CM/8/21/PL and CM/10/21/PL

OBJECTION

I make this representation in the shadow of your Councils refusals of earlier applications CM/25/20/PL, CM/60/19/CLE, CM/38/18/PL my comments on those applications still stand.

corten flood wall and gate
CM_flood wall + gate
Scale: 1:100 + 1:50 @ A2
Date:18.01.2021

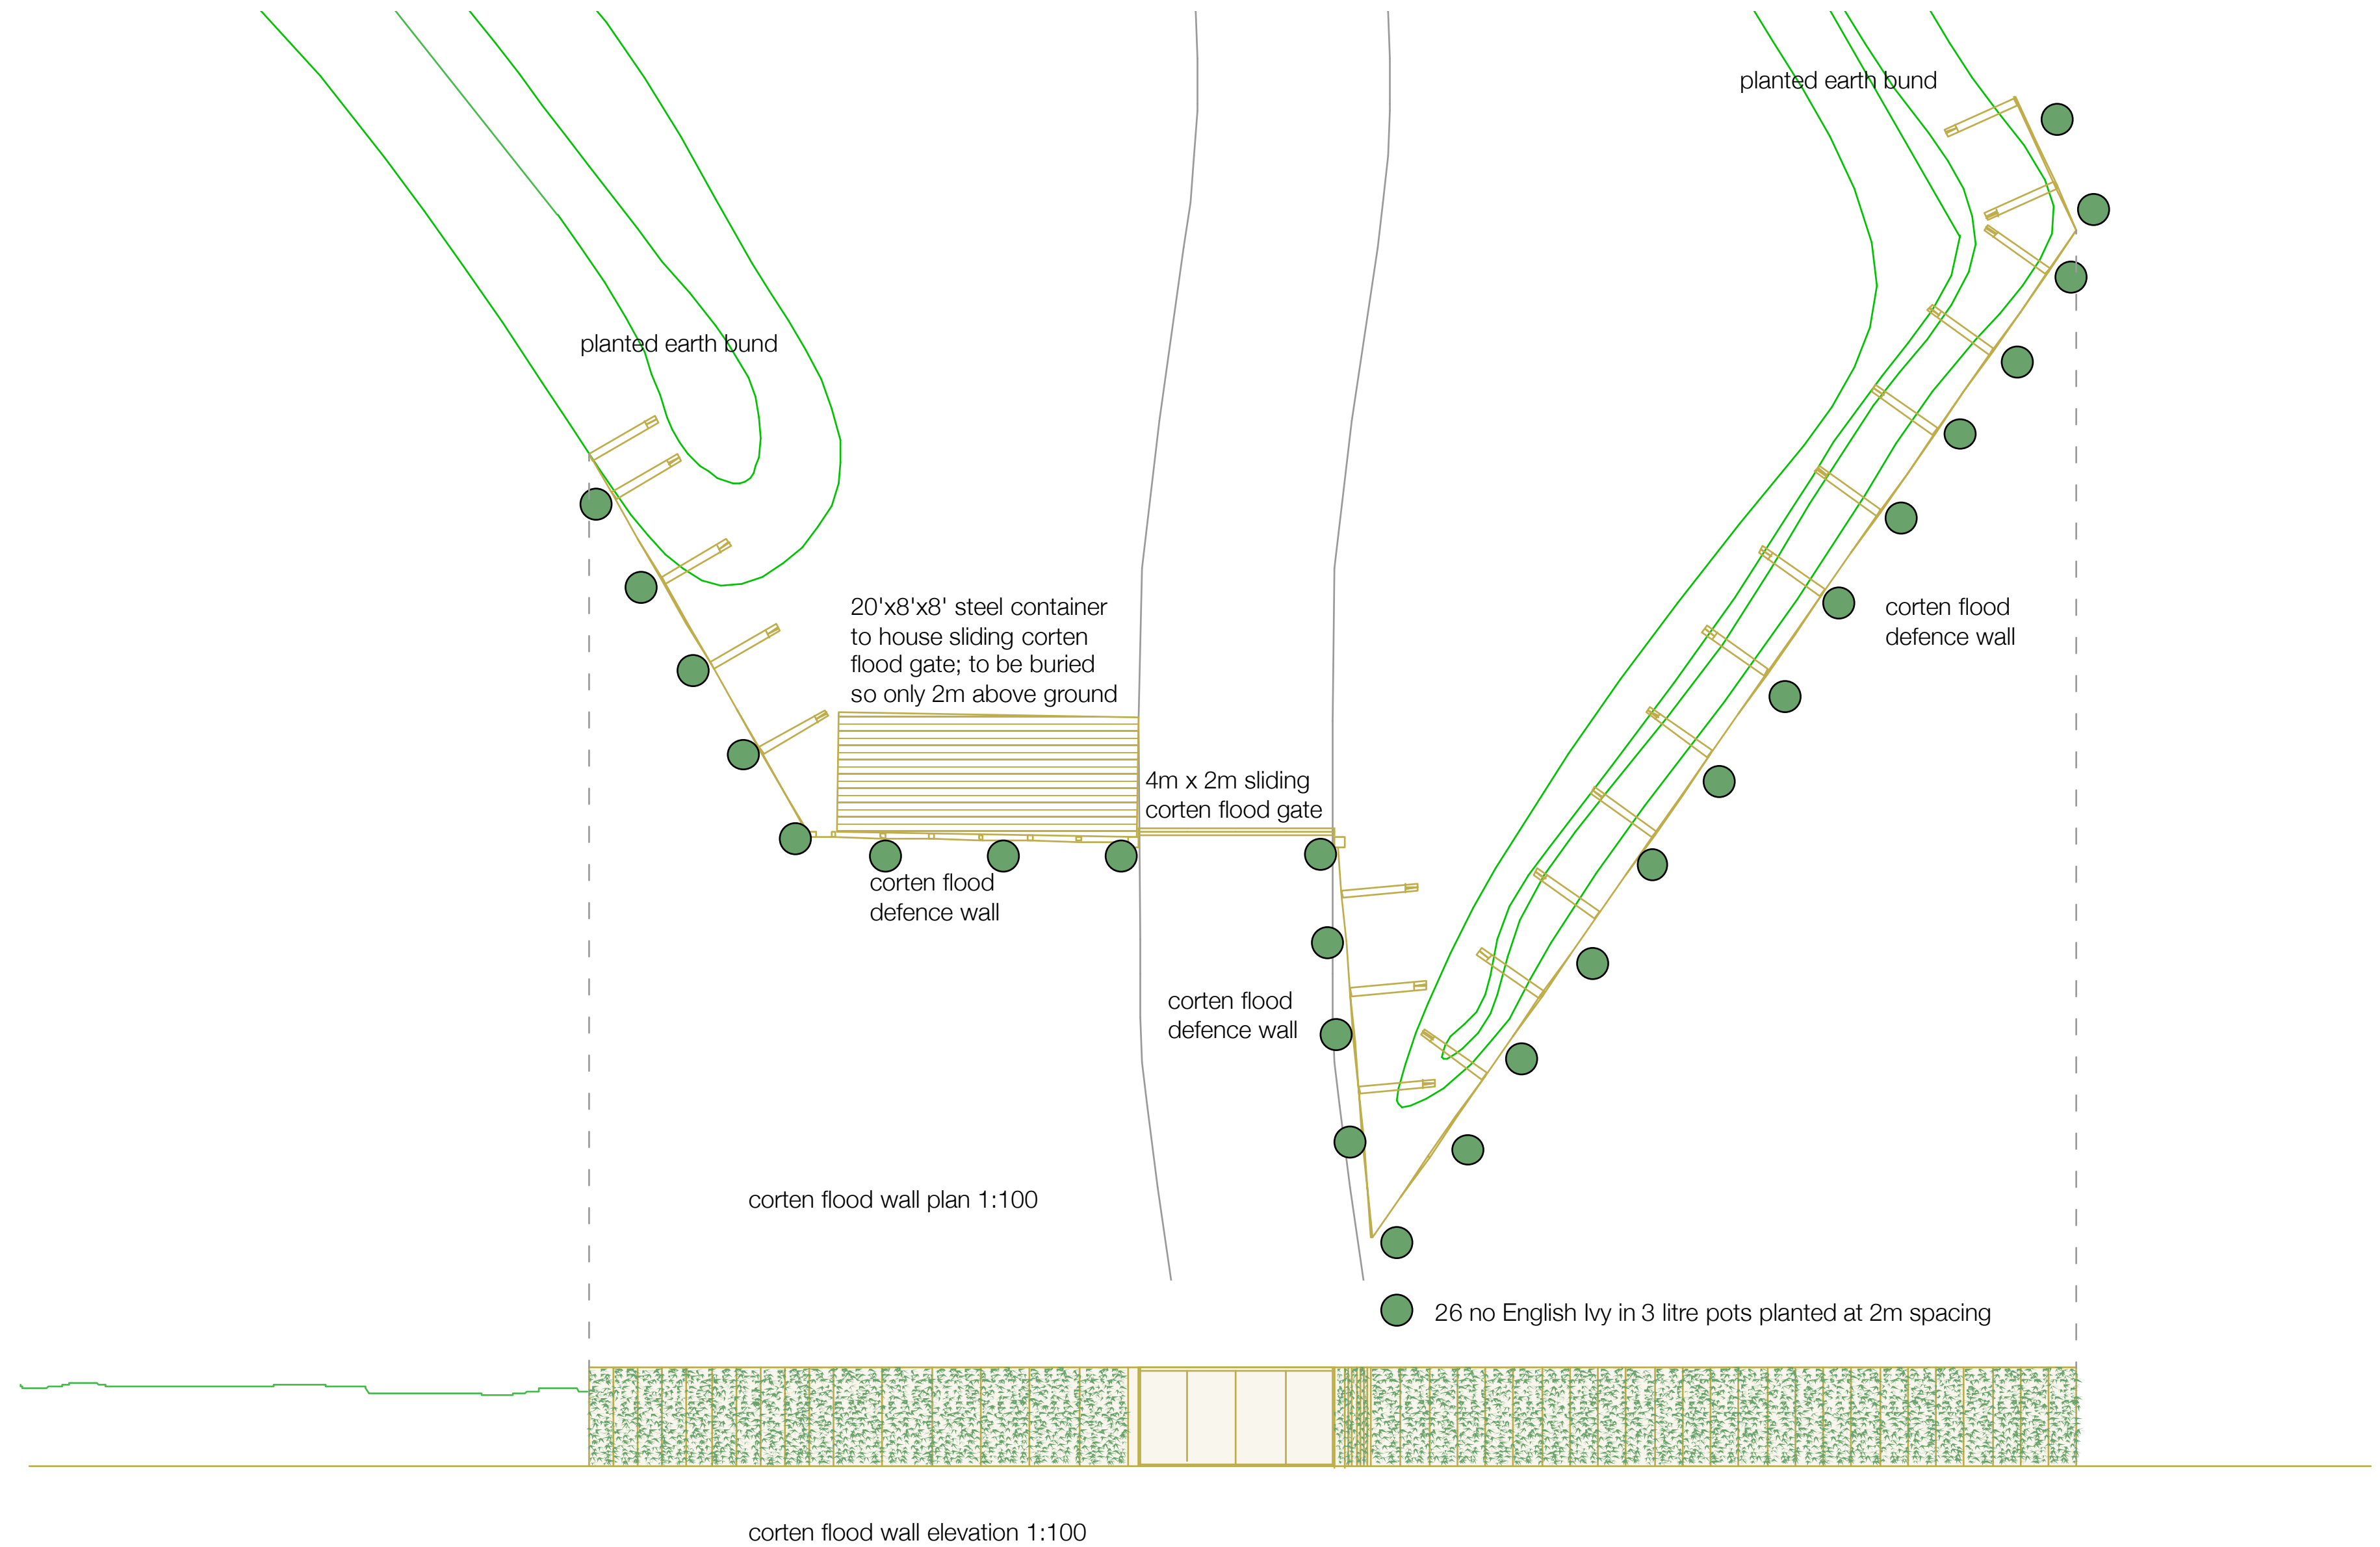
The corten fencing and shipping containers are apparently justified *"to withstand the pressure and force of coastal flooding which hits the site at its entrance"*. Note the use of the present tense.

This justification begs the question, how is it that so much shrubbery and trees exist between the entrance gates and the coast that is completely unaffected by this imagined force and pressure?

Whether they will be needed in future years (by 2115 is mentioned) is an entirely different proposition and does not justify them in the present.

We have the benefit of seeing them installed as the applicant has presumed planning permission for them will be obtained; they are certainly out of keeping against the backdrop of the SSSI sand dunes, open countryside and historic traditional Mill buildings. It is noteworthy that the applicant would choose shipping containers as his choice of building material knowing that your council previously refused consent to even have them on the site even on a temporary basis due to their harmful visual impact.

pond planting
CM_PP01
Scale:1:500 @ A2
Date:18.01.2021

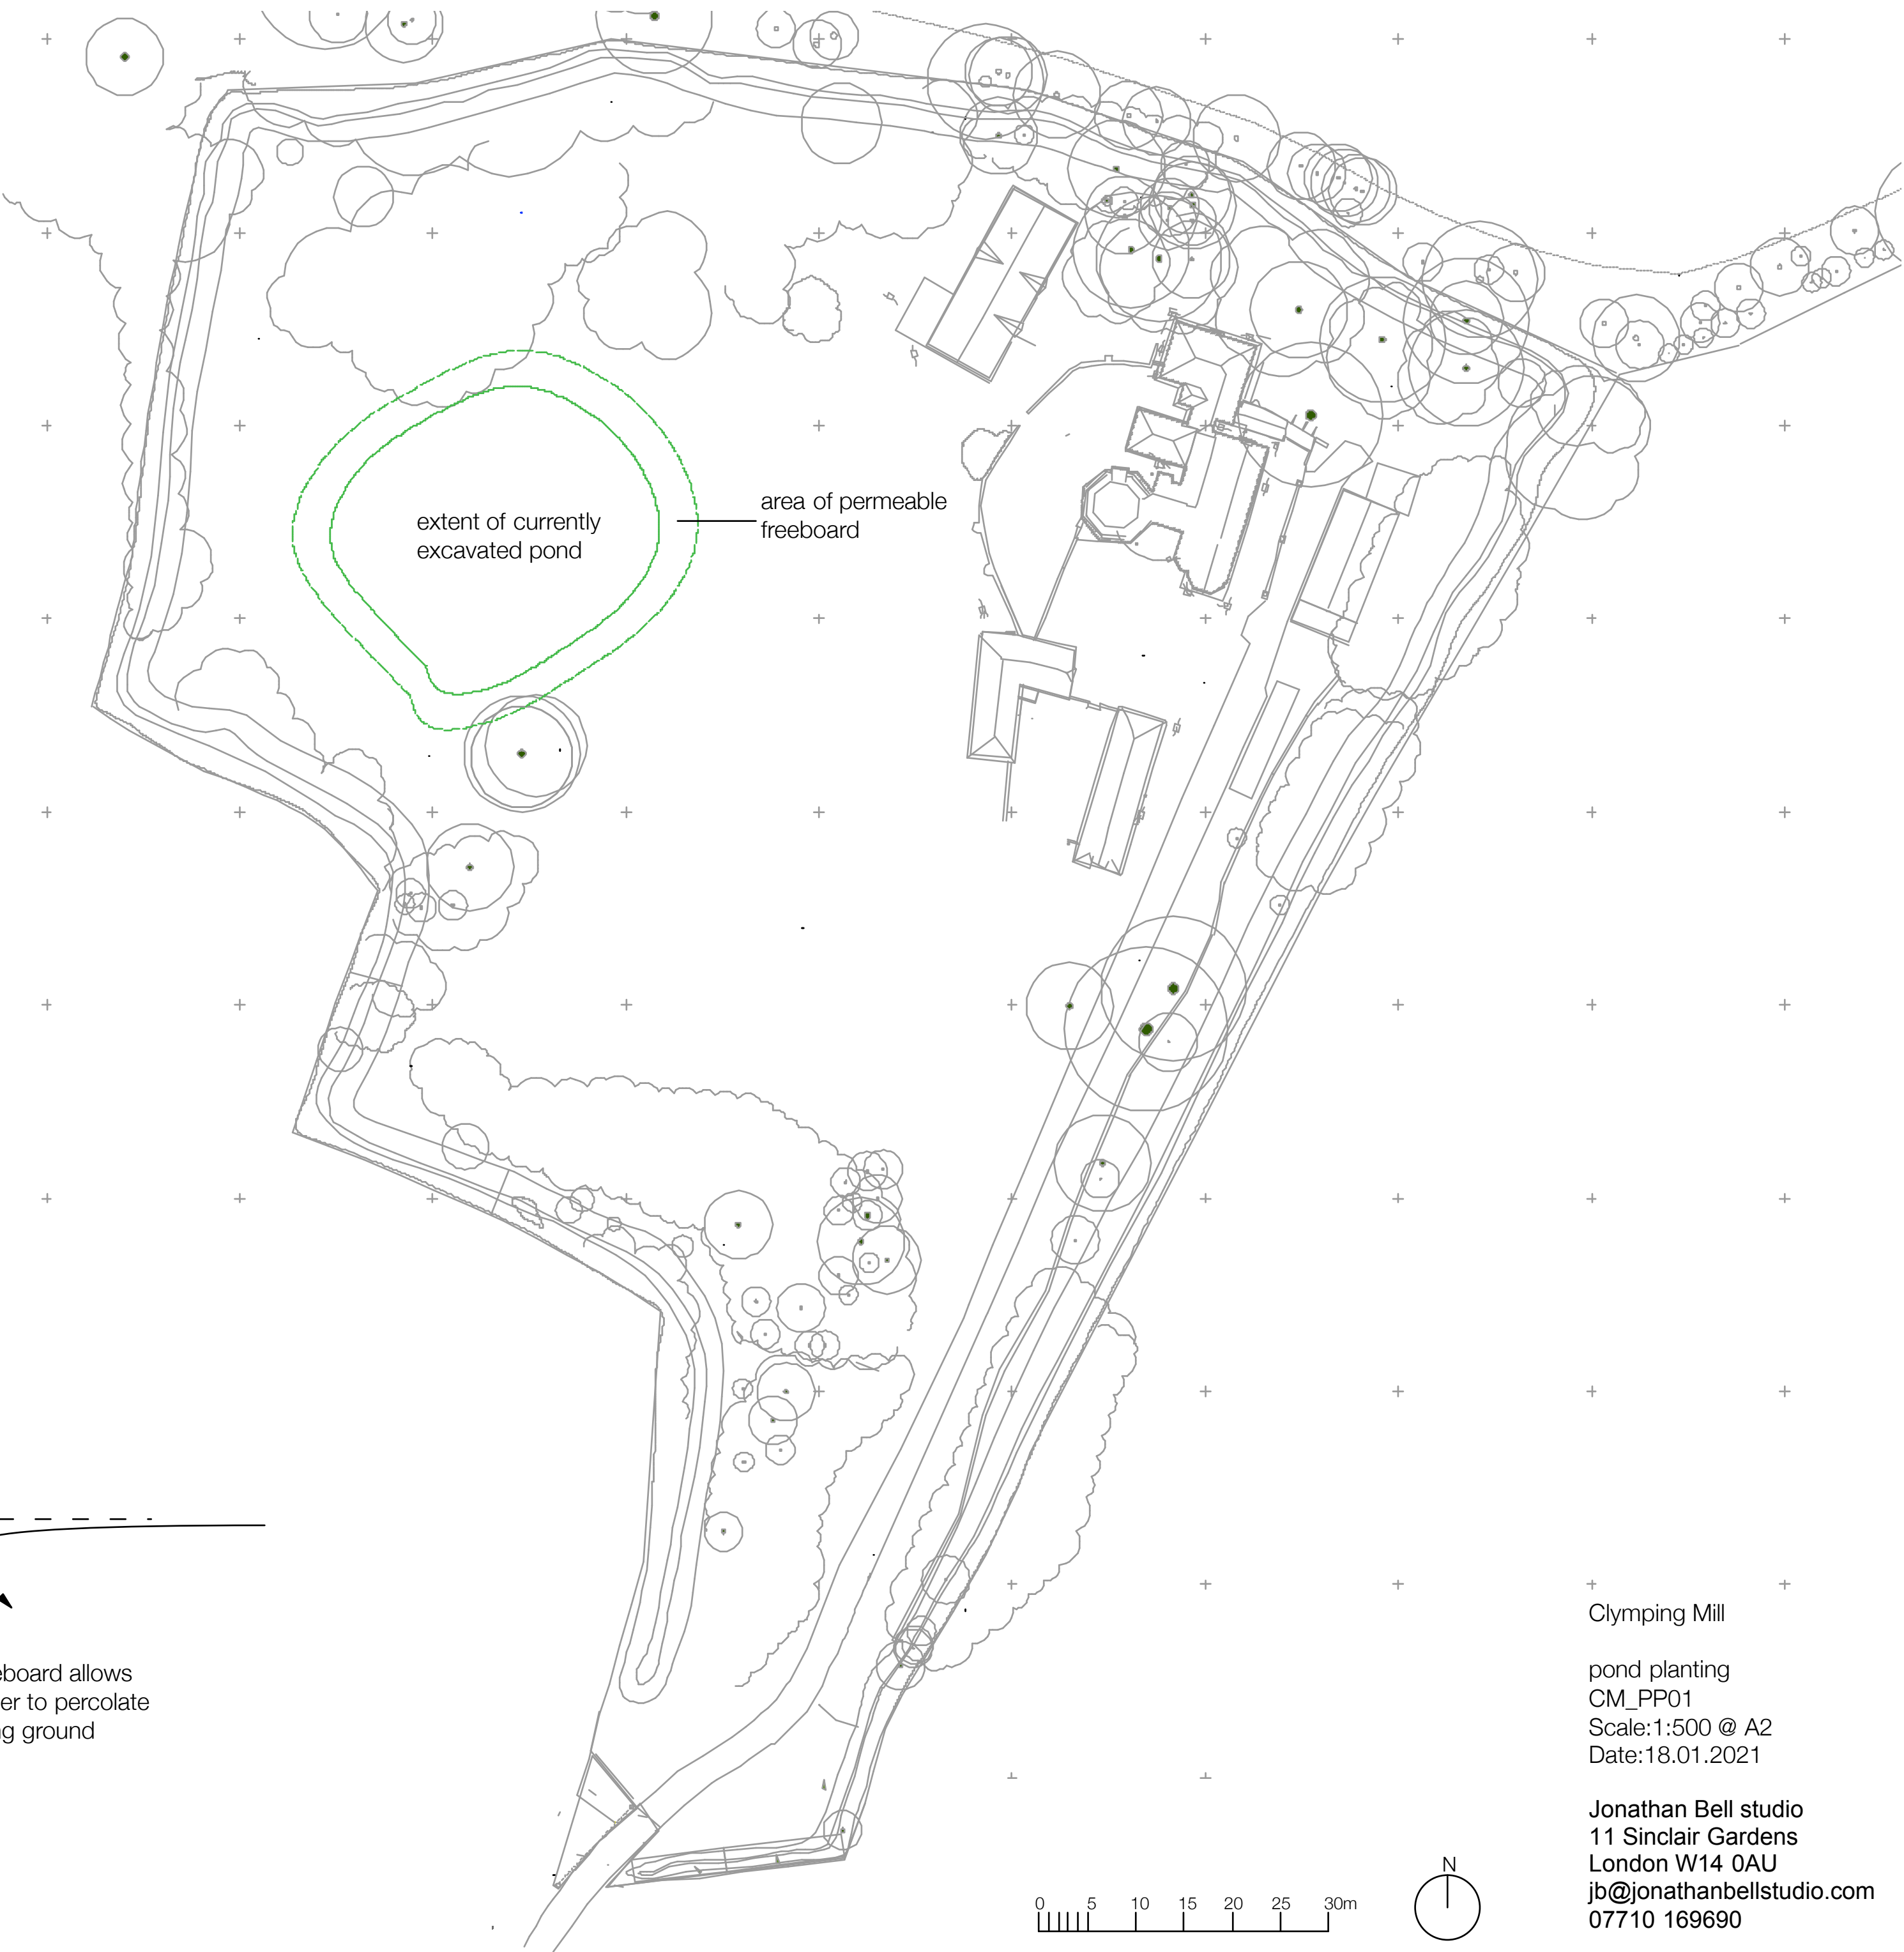
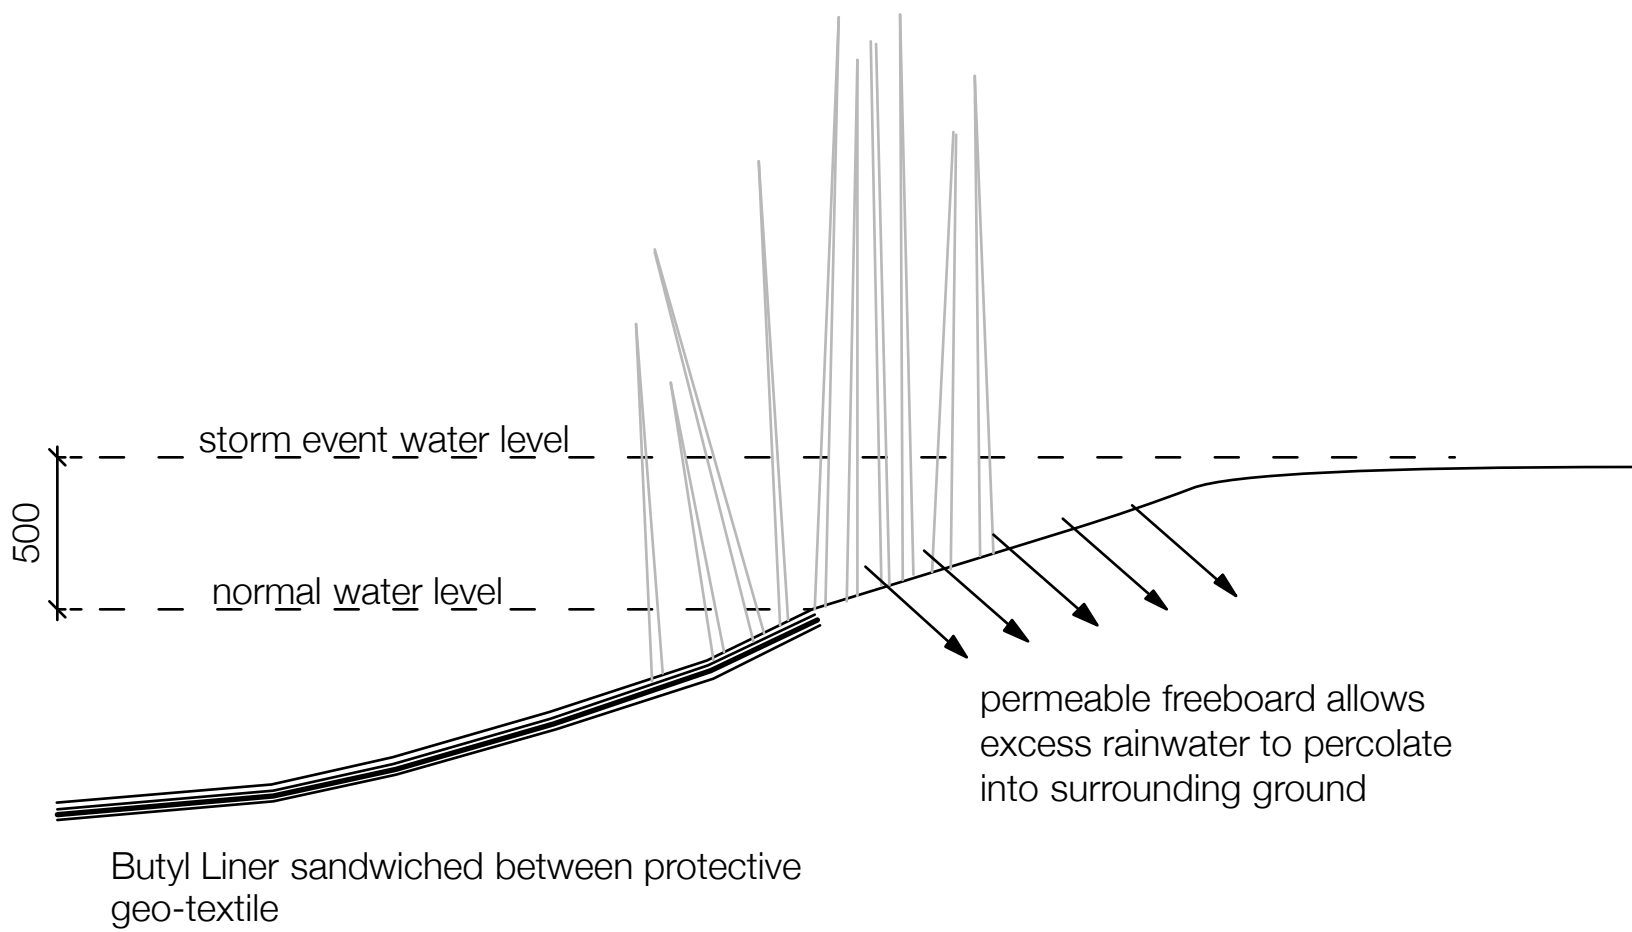
- 1) The source of the water shown in the photographs
- 2) The need for the bunding and pond
- 3) The need of the corten steel and shipping container fencing

It is important to consider that an alternative source of the water might be groundwater, were that to be the case then the introduced bunding that now surrounds the site may have a damaging effect on the fabric of the listed buildings as the water can no longer escape.

I can see no need for these bunds. It is worth noting that in recent days the applicant has raised many of the banks including along the northern boundary and in doing so has completely smothered the newly planted trees, further damaged the existing trees, setting back the nature recovery once again and during bird nesting season. The bund there is now of such a height that footpath users can no longer see into the site where so much unauthorised activity has taken place and much of it upon land that we own, it certainly now acts as a visibility barrier.
